MECKLENBURG COUNTY
Park and Recreation Department

MEMORANDUM

DATE: March 23, 2020

RE: Rezoning Petition #2019-115 – Northwood Development, LLC

SHEET #:  
**RZ-7.0B2**

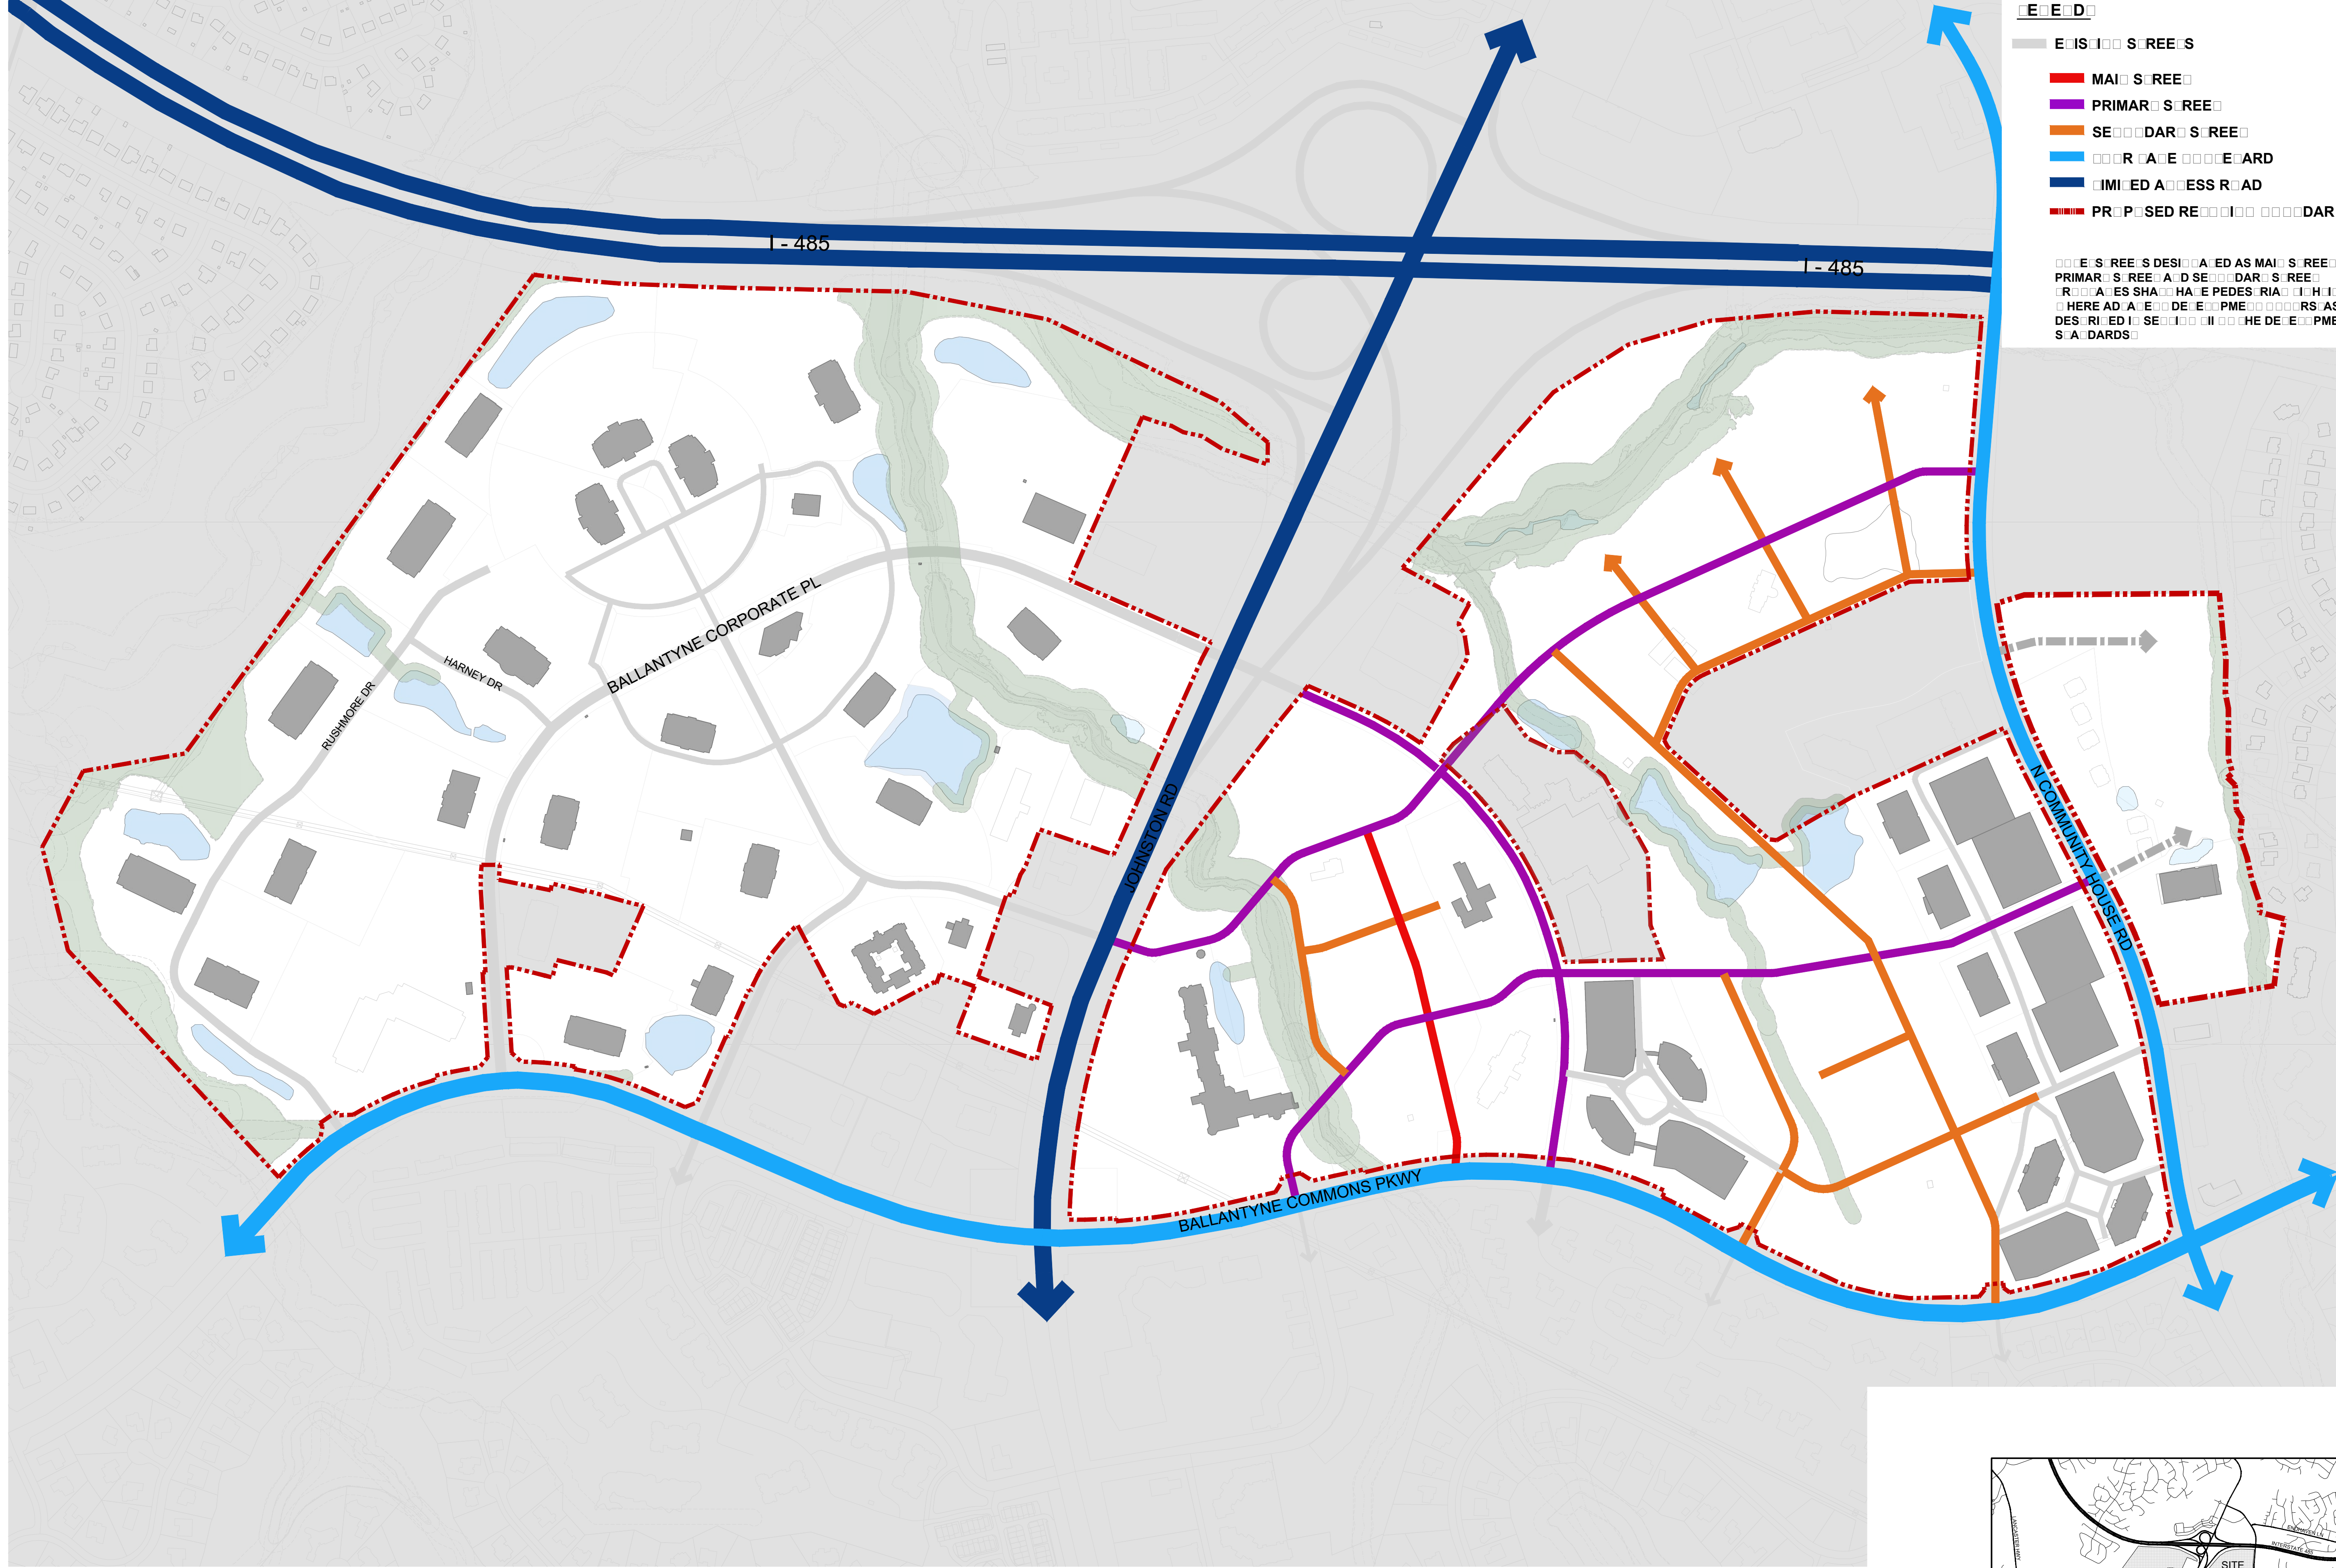
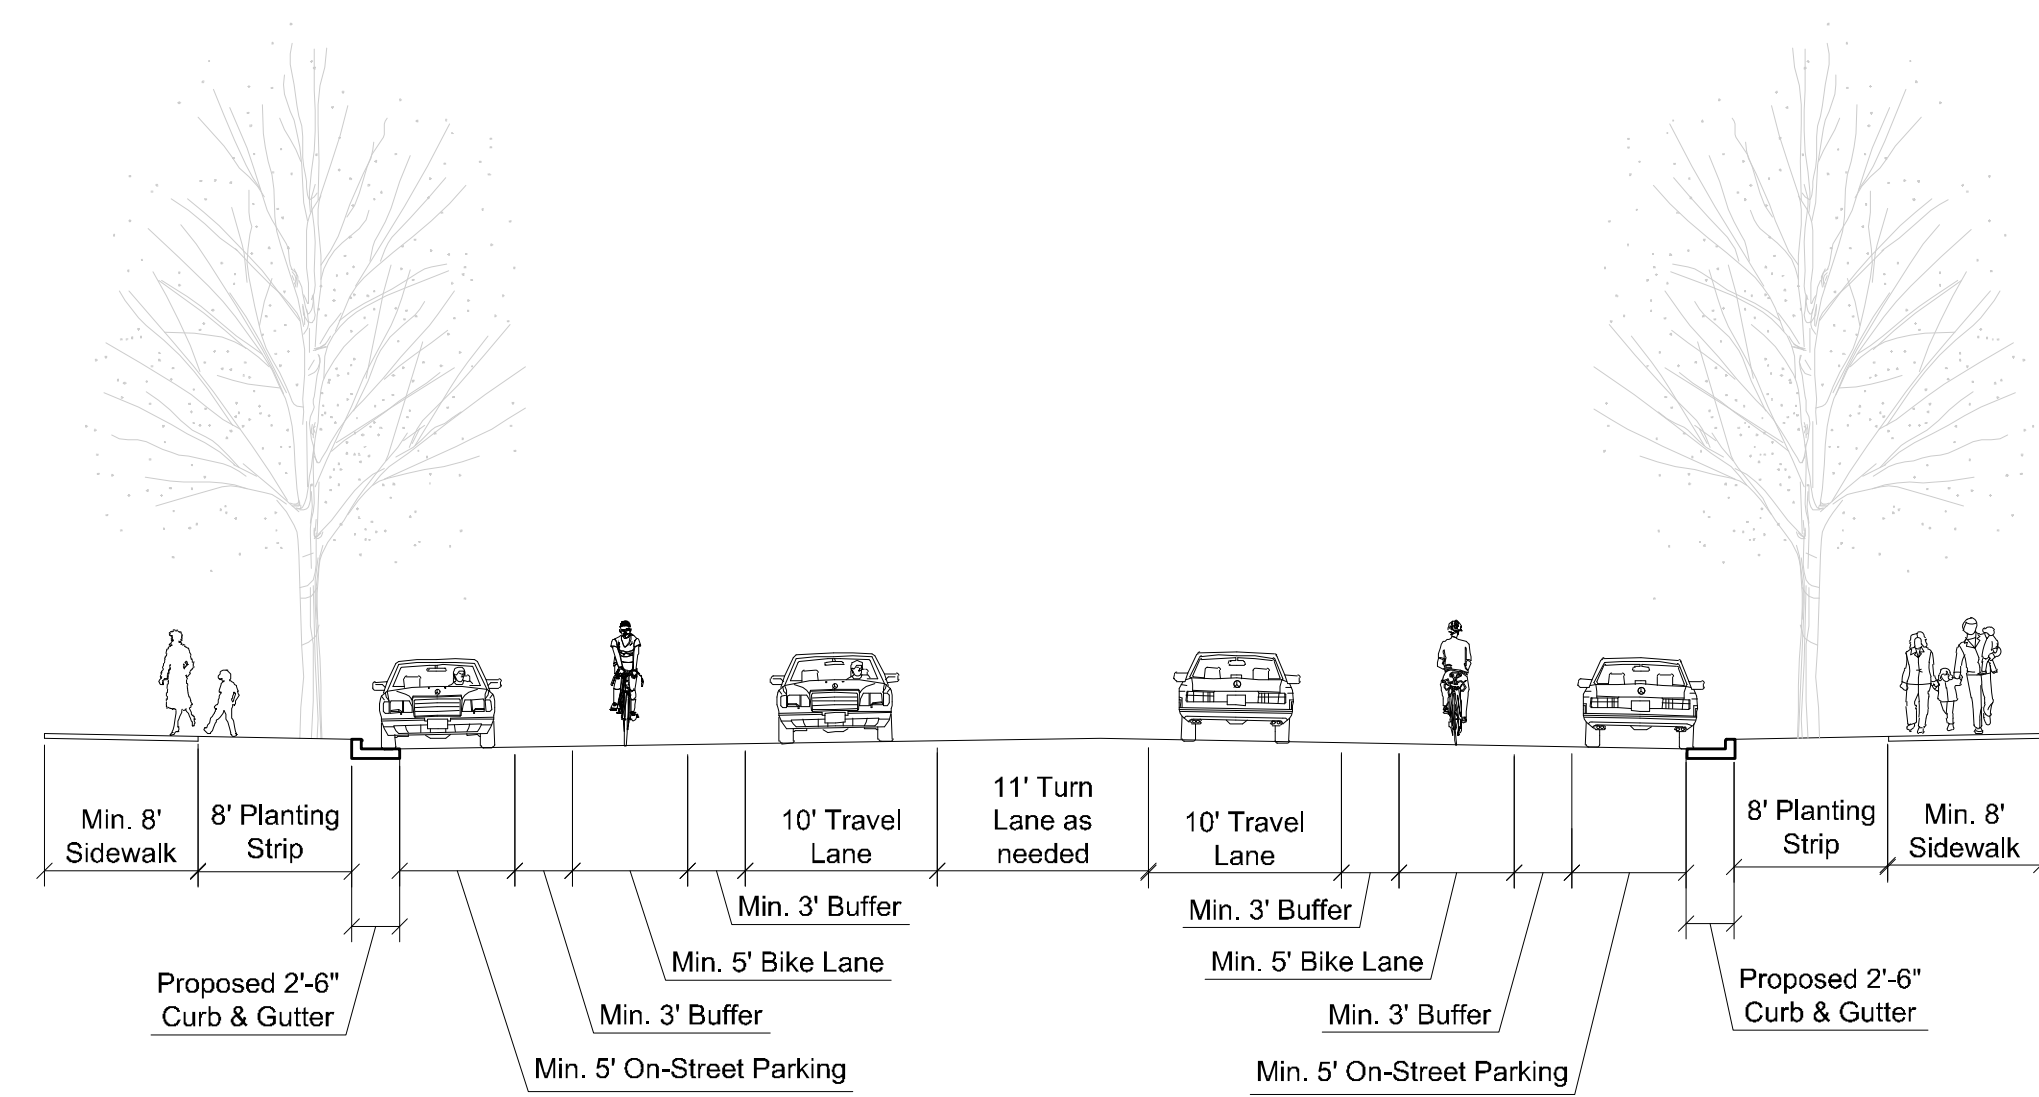
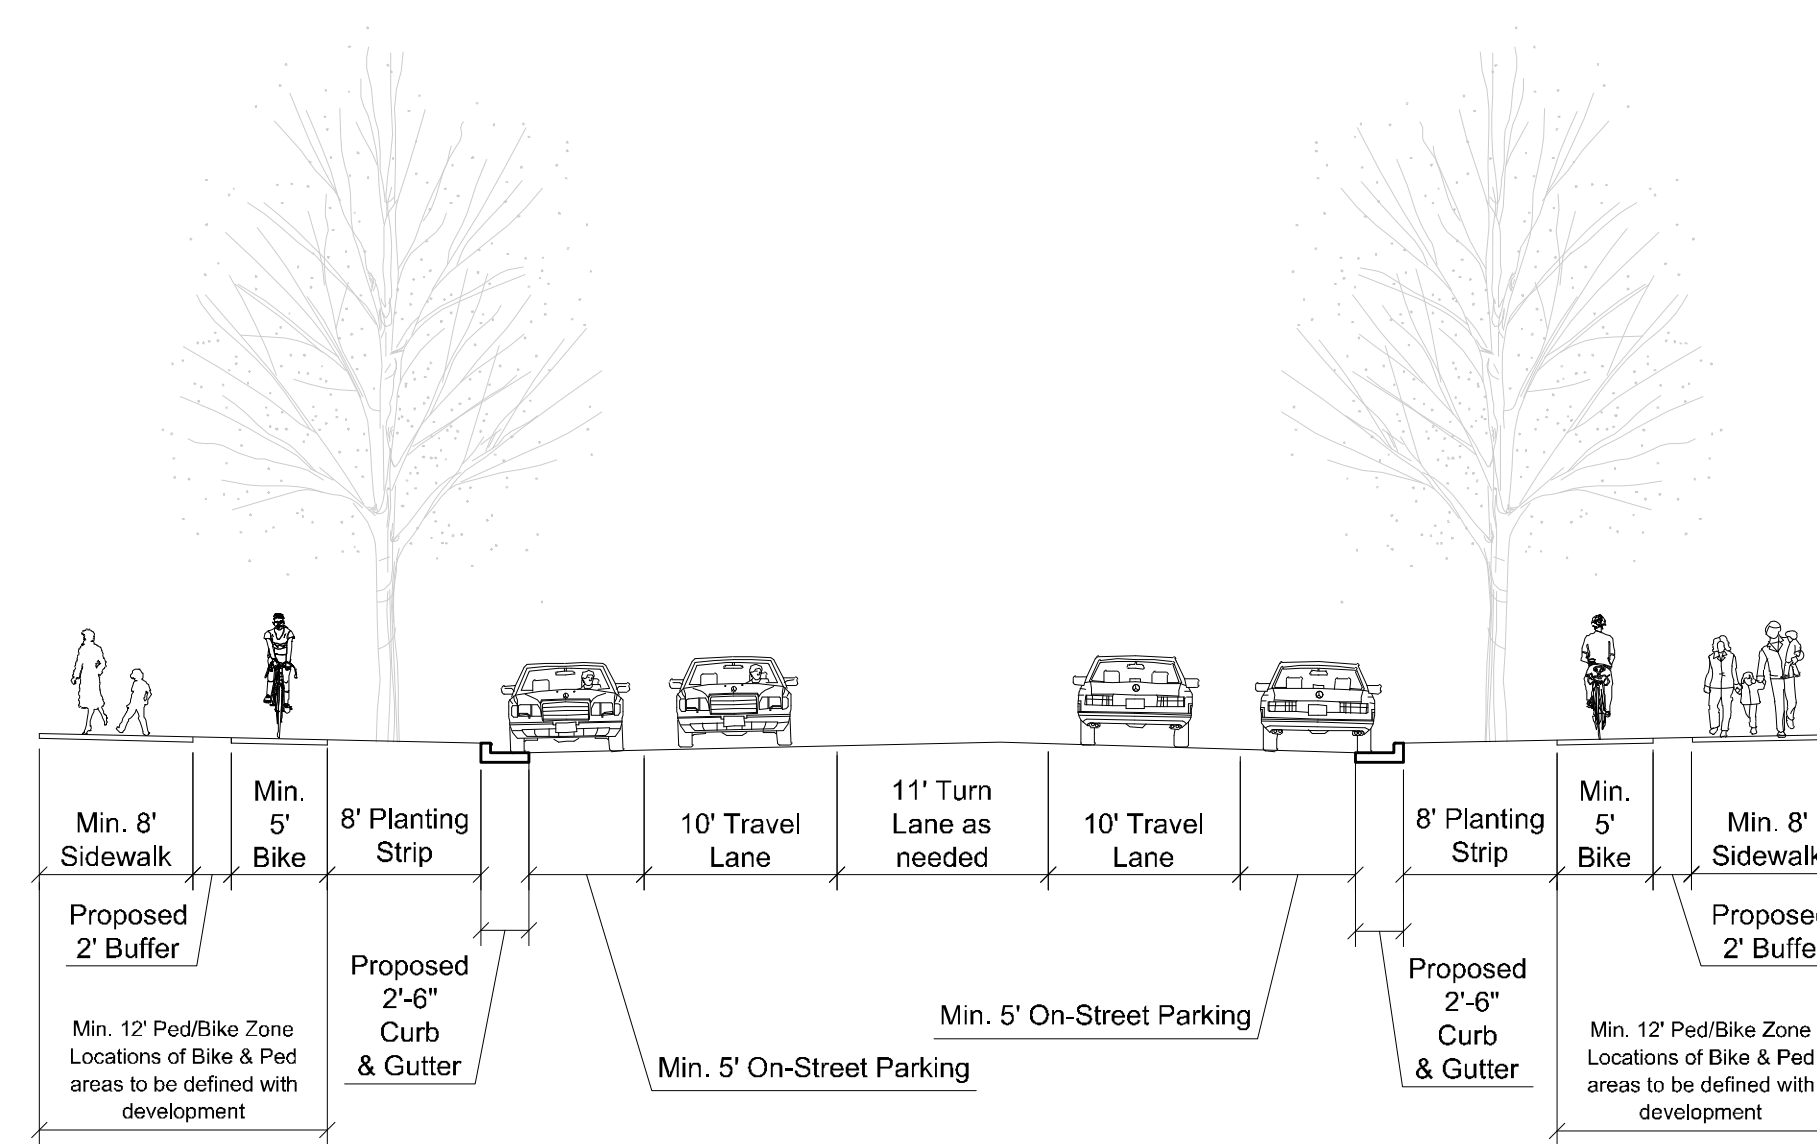
1. We acknowledge and appreciate the McAlpine Creek Greenway Access Trail towards I-485. We require any developer-built greenway trails be built to MCPR Greenway Standards. These standards are available upon request by the petitioner.
2. For a rezoning of this size, we understand the petitioner is going to provide several park areas and amenities. While we originally requested these park parcels be dedicated and conveyed to Mecklenburg County, we will accept the privately-owned park parcels as long as these recreation spaces are truly public and accessible to all.
3. We have no further comments at this time.
